Concept Approval SSD 5175 includes the following conditions relevant to the application of the Eastern Creek Business Hub Design Guidelines:

The following table considers the requirements of the Design Guidelines (DG) against the proposed Stage 1 concept and identifies:

| Eastern Creek Business Hub – Design Guidelines |

Figure 52: Development Control Plan - Lot 2 (not to scale)

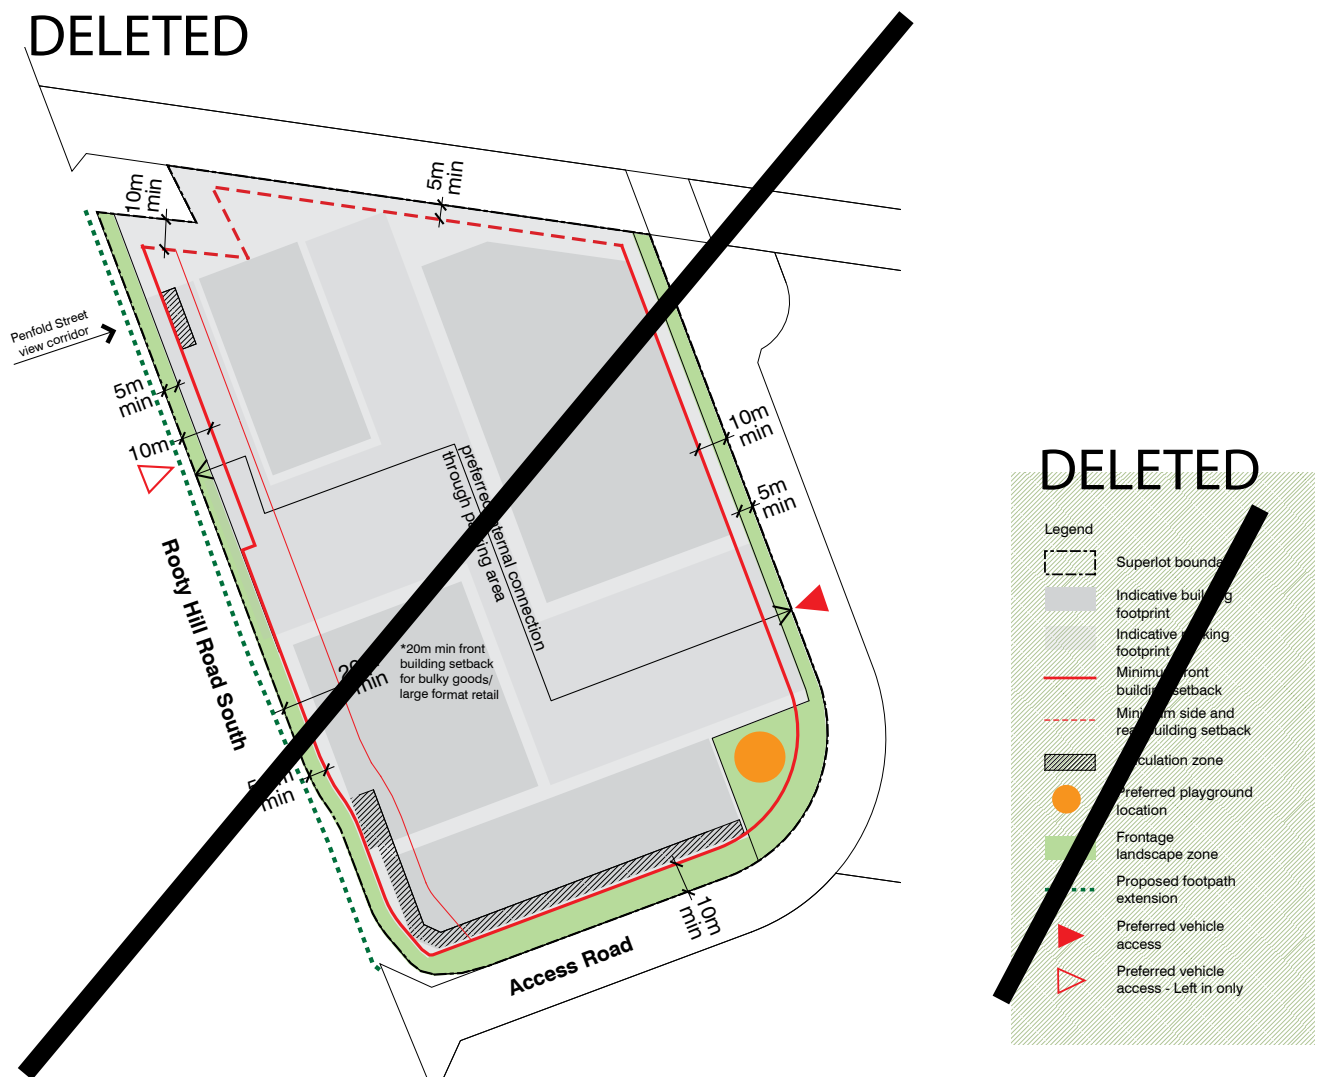
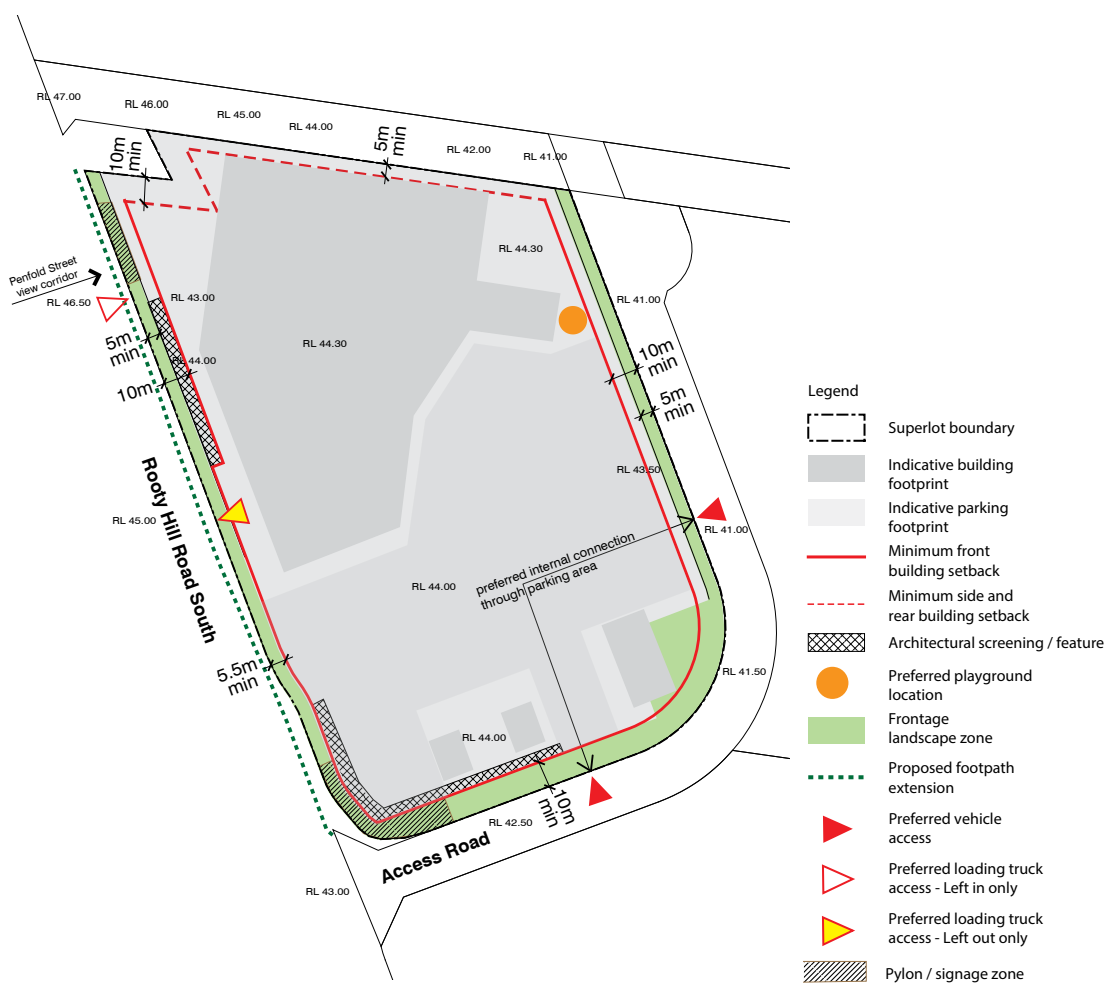
| Eastern Creek Business Hub – Design Guidelines |                                                                                                                                                                                                                                                                                                                                                                                                                                                                                                                                                                                                                                                                                                                                                                                                                                                                                                                                                                                                                                                                                                                                                                                                                                                                                                                                                                                                                     |                                                                                                         |                                                                    |
|------------------------------------------------|---------------------------------------------------------------------------------------------------------------------------------------------------------------------------------------------------------------------------------------------------------------------------------------------------------------------------------------------------------------------------------------------------------------------------------------------------------------------------------------------------------------------------------------------------------------------------------------------------------------------------------------------------------------------------------------------------------------------------------------------------------------------------------------------------------------------------------------------------------------------------------------------------------------------------------------------------------------------------------------------------------------------------------------------------------------------------------------------------------------------------------------------------------------------------------------------------------------------------------------------------------------------------------------------------------------------------------------------------------------------------------------------------------------------|---------------------------------------------------------------------------------------------------------|--------------------------------------------------------------------|
| <b>3.6.16 Lot 2</b>                            | Lot 2 is located adjacent to Rooty Hill Road South and the Access Road.                                                                                                                                                                                                                                                                                                                                                                                                                                                                                                                                                                                                                                                                                                                                                                                                                                                                                                                                                                                                                                                                                                                                                                                                                                                                                                                                             | <p><b>Deleted:</b></p> <p>This site is most suited to a range of uses including convenience retail,</p> | The proposed use of childcare was added to the description of land |

| Eastern Creek Business Hub – Design Guidelines |                                                                                                                                                                                                                                                                                                                                                                                                                       |                                                                                                                                                                                                                                                                                                                                                                                                                                                                                                                                                                                                                                                                                                                                                                                                                                                                                                                                                                                                                                                 |                                                                                                                                                                                                                                                                                                                                                                                                                                                                                                                                                                                                                                                                                                                                                                                                                                                                                                                                                                                                                                                             |
|------------------------------------------------|-----------------------------------------------------------------------------------------------------------------------------------------------------------------------------------------------------------------------------------------------------------------------------------------------------------------------------------------------------------------------------------------------------------------------|-------------------------------------------------------------------------------------------------------------------------------------------------------------------------------------------------------------------------------------------------------------------------------------------------------------------------------------------------------------------------------------------------------------------------------------------------------------------------------------------------------------------------------------------------------------------------------------------------------------------------------------------------------------------------------------------------------------------------------------------------------------------------------------------------------------------------------------------------------------------------------------------------------------------------------------------------------------------------------------------------------------------------------------------------|-------------------------------------------------------------------------------------------------------------------------------------------------------------------------------------------------------------------------------------------------------------------------------------------------------------------------------------------------------------------------------------------------------------------------------------------------------------------------------------------------------------------------------------------------------------------------------------------------------------------------------------------------------------------------------------------------------------------------------------------------------------------------------------------------------------------------------------------------------------------------------------------------------------------------------------------------------------------------------------------------------------------------------------------------------------|
|                                                | <p>This site is most suited to a range of uses including convenience retail, large format retail and bulky goods.</p> <p>It is expected that the development of Lot 2 be of high design quality that provides an appropriate address to Rooty Hill Road South and the surrounding context. To achieve this, developments are to adhere to the following site specific development controls outlined in Figure 53.</p> | <p>large format retail and bulky goods.</p> <p>It is expected that the development of Lot 2 be of high design quality that provides an appropriate address to Rooty Hill Road South and the surrounding context. To achieve this, developments are to adhere to the following site specific development controls outlined in Figure 53.</p> <p><b>Inserted:</b><br/>This site is most suited to a range of uses including convenience retail, large format retail, bulky goods and childcare.</p> <p>It is expected that the development of Lot 2 be of high design quality that provides an appropriate address to its proposed internal access road and the surrounding context. To achieve this, developments are to adhere to the following site specific development controls outlined in Figure 51.</p> <p><b>Images:</b></p> <ul style="list-style-type: none"> <li>Figure 53: Development Control Plan- Lot 2, amended to reflect proposed revised concept plan, now captioned "Figure 52: Development Control Plan- Lot 2".</li> </ul> | <p>uses within Lot 2.</p> <p>An active address to Rooty Hill Road South is no longer appropriate, due to the considerable change in topography between Rooty Hill Road South level and the approved level for the site. This has also led to relocation of the village centre to face the parklands.</p> <p>Although the loading dock is now facing Rooty Hill Road South, its visual impact is considered minimal due to a change in topography. In addition architectural screening will be provided at road level.</p> <p>Due to the reconfiguration of the built form, the articulation zones were no longer applicable, and removed from Figure 53. Architectural screening/feature and pylon signage zones were added to the diagram.</p> <p>The prescribed areas for architectural screening were strategically located to mitigate unwanted visual impacts of the loading zones, and car parking. The pylon signage zones were strategically located to maximize visual catchment, and facilitate wayfinding to the Eastern Creek Business Hub.</p> |
